From: Colin Sharpe
Sent: 02 August 2012 08:55
To: Jane Tucker
Subject: FW: 0342 Higher Trapp

3/2012/0342

From: simonstone [mailto:simonstonepc@talktalk.net]
Sent: 01 August 2012 19:12
To: Colin Sharpe
Subject: 0342 Higher Trapp

1:750

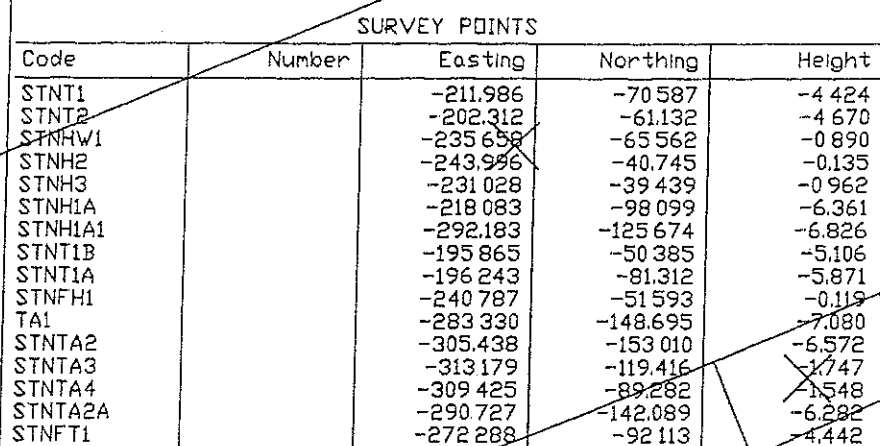
Tractor Shed development not shown on the Existing Site plan. Where the landscaping conditions not completed and were breached.
